Rezoning Transportation Analysis

Petition Number: 2022-199

Date	Description
4-27-23	First Review (TM)

The site is adjacent to US Highway 29, a State-maintained major throughfare, and north of Wrayhill Drive, a City-maintained local street. A Traffic Impact Study (TIS) is not required for this site due to the site generating less than 2500 daily trips. Site plan and/or conditional note revisions are needed to commit to Realigning site plan in coordination with NCDOT, Provide connectivity with surrounding public roadways being constructed by adjacent developments and conditional note revisions. Further details are listed below.

**SCHEMATIC
 SITE PLAN**

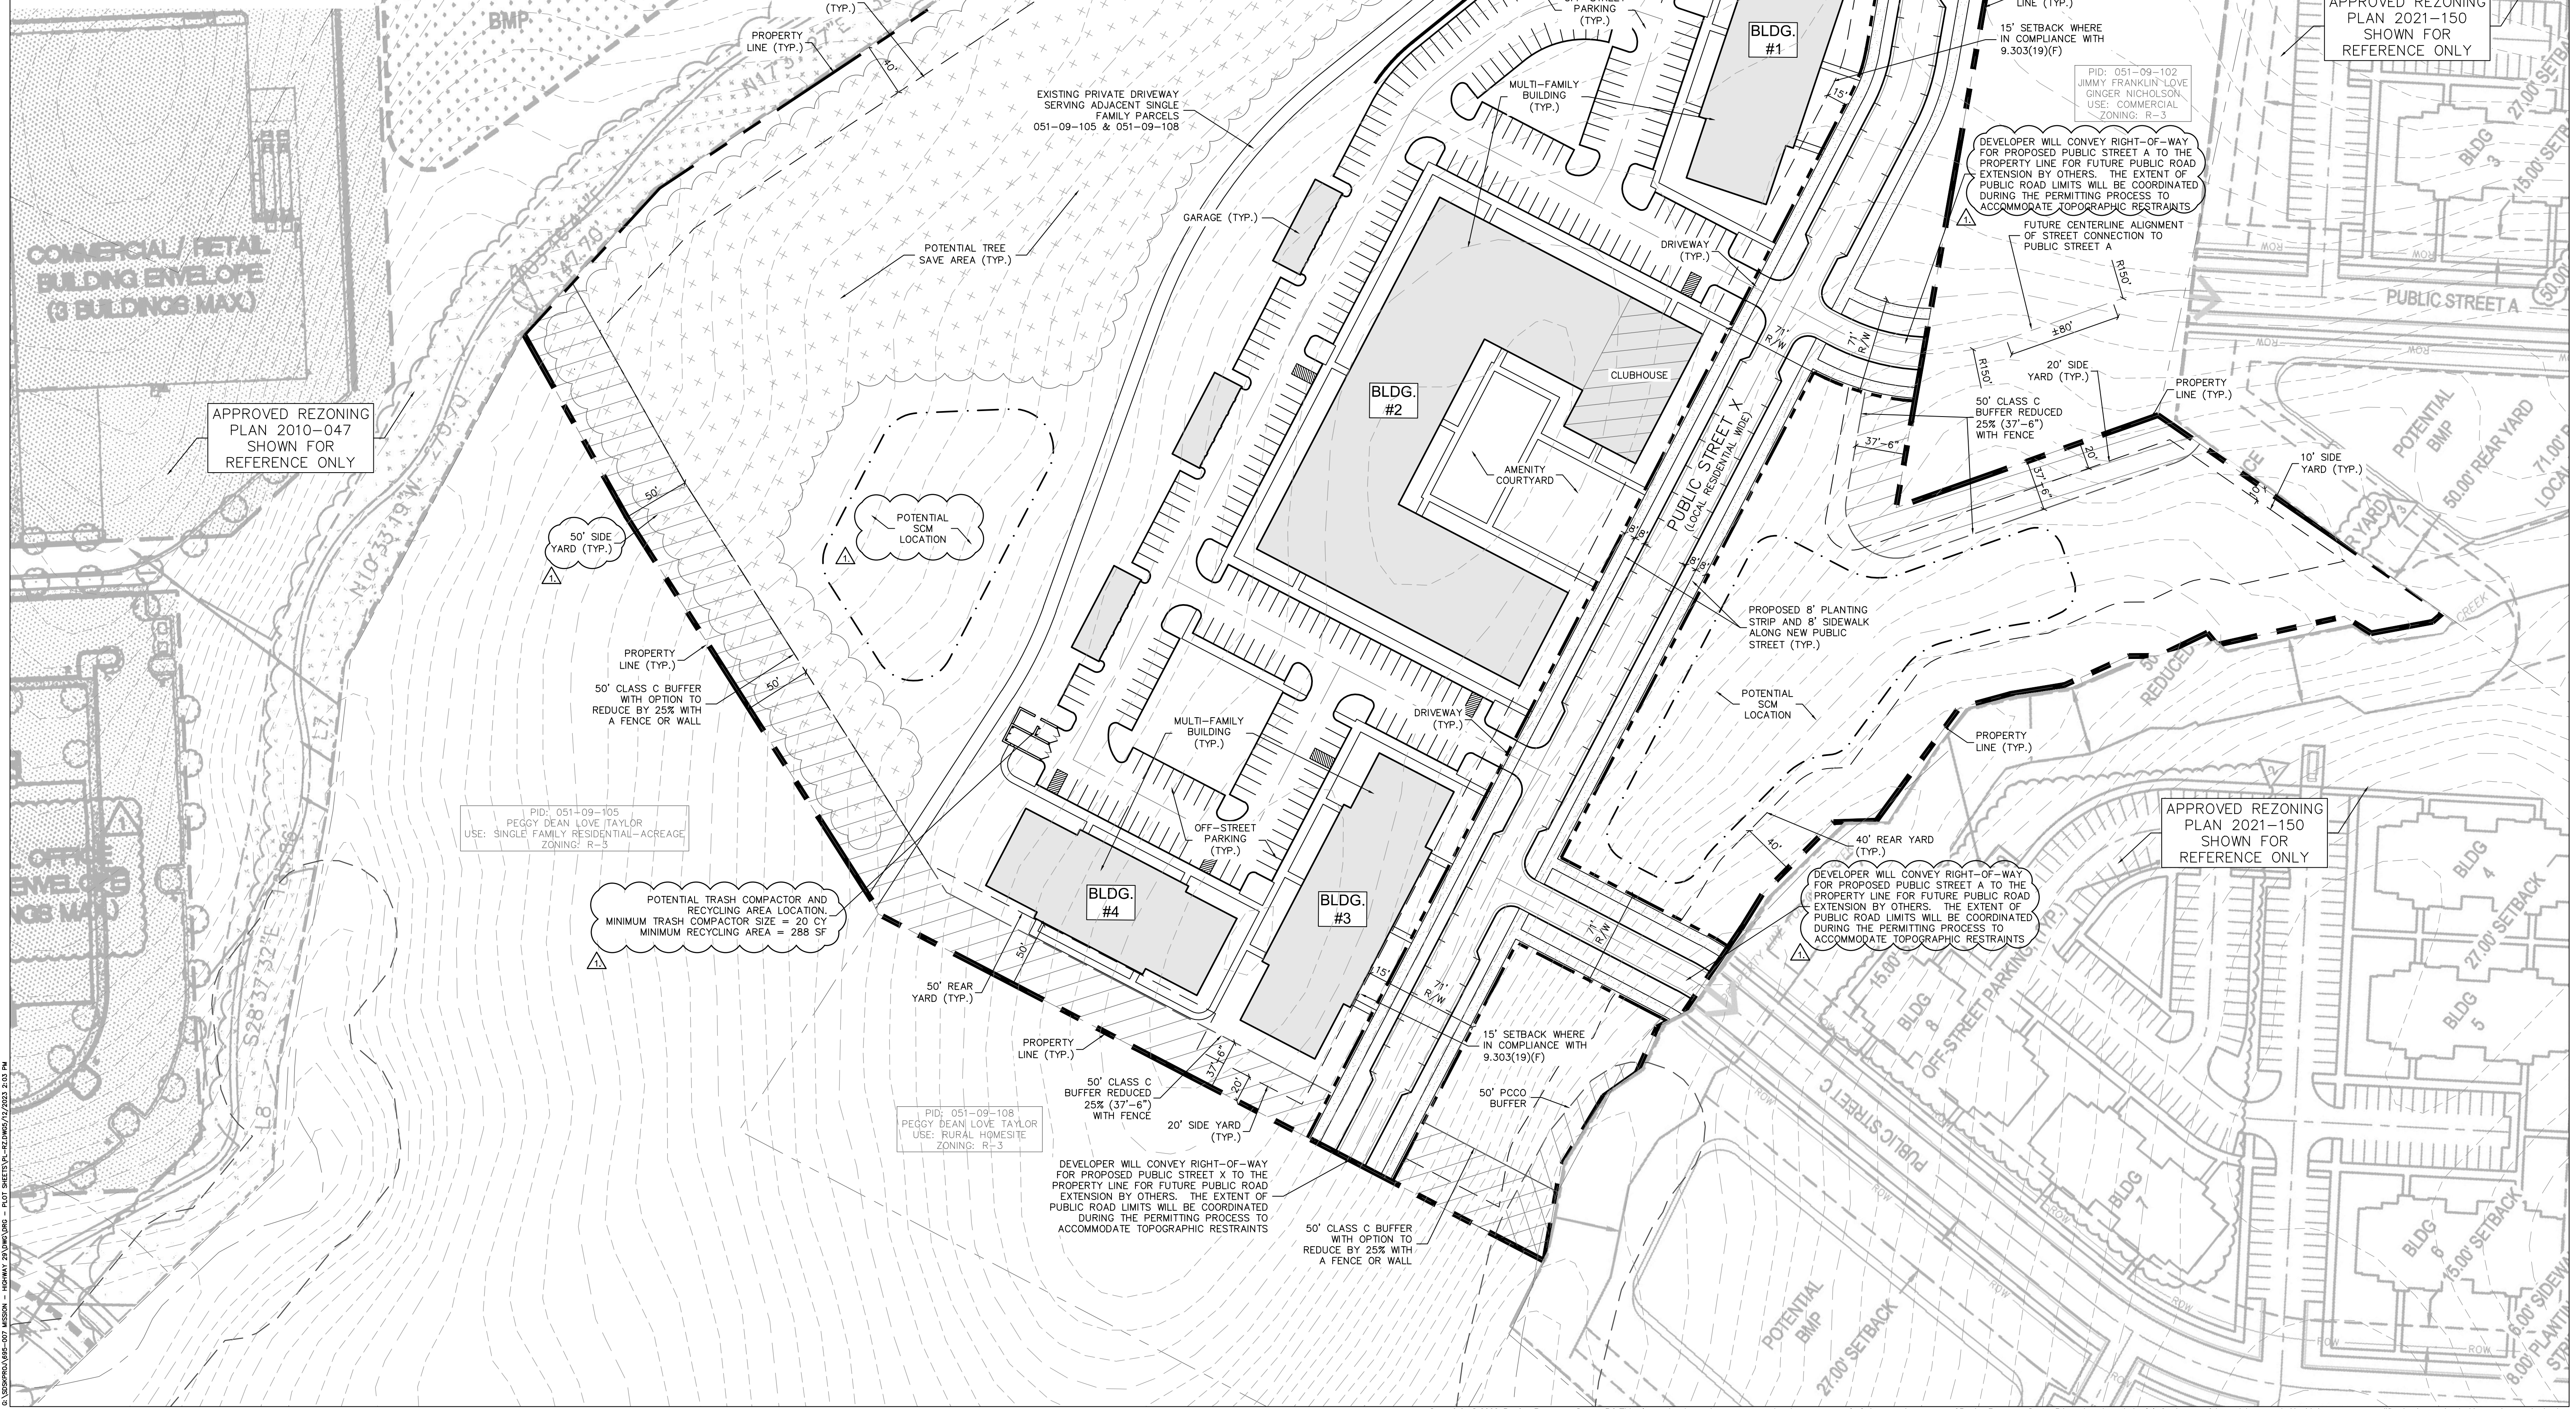
- a. **US 29 Highway:** Location of curb and gutter to be moved to 44 feet from roadway centerline to accommodate the Charlotte Streets Map with a roadway typical section of 6+ Boulevard, Shared Use Path.

NOTE: Additional distance from center line to back of curb may be required in locations where a median is present or around intersections and interchanges. Add a conditional note that the final location of the curb line is to be determined during the permitting process.

Label and dimension the curb and gutter from the centerline for each road on the site plan.

4. Revise site plan and conditional note(s) to commit to realign the site access towards the western property line to accommodate the surrounding development in coordination with NCDOT. The existing private driveways serving neighboring properties shall be relocated. Site plan shall screen in left over to Floyd smith park that is being installed by SDRMF-2022-00078.

5. Revise site plan and conditional note(s) to commit to connecting to the stub street from the neighboring developments.
6. Revise site plan and conditional note(s) to commit to connecting to constructing the dedicated right turn lane into the site with 150-feet of storage in coordination with NCDOT.

10. Revise site plan and conditional note(s) to construct 8-foot planting strips and 12-foot multi-use path on Tryon Road. The site plan shall label and dimension both items from the back of curb and gutter or edge of pavement. Add conditional note The entire facility must be outside of the right of way and within a public access easement. Add conditional note committing to construction and maintenance of the 12-foot multi-use paths on Tryon Road.
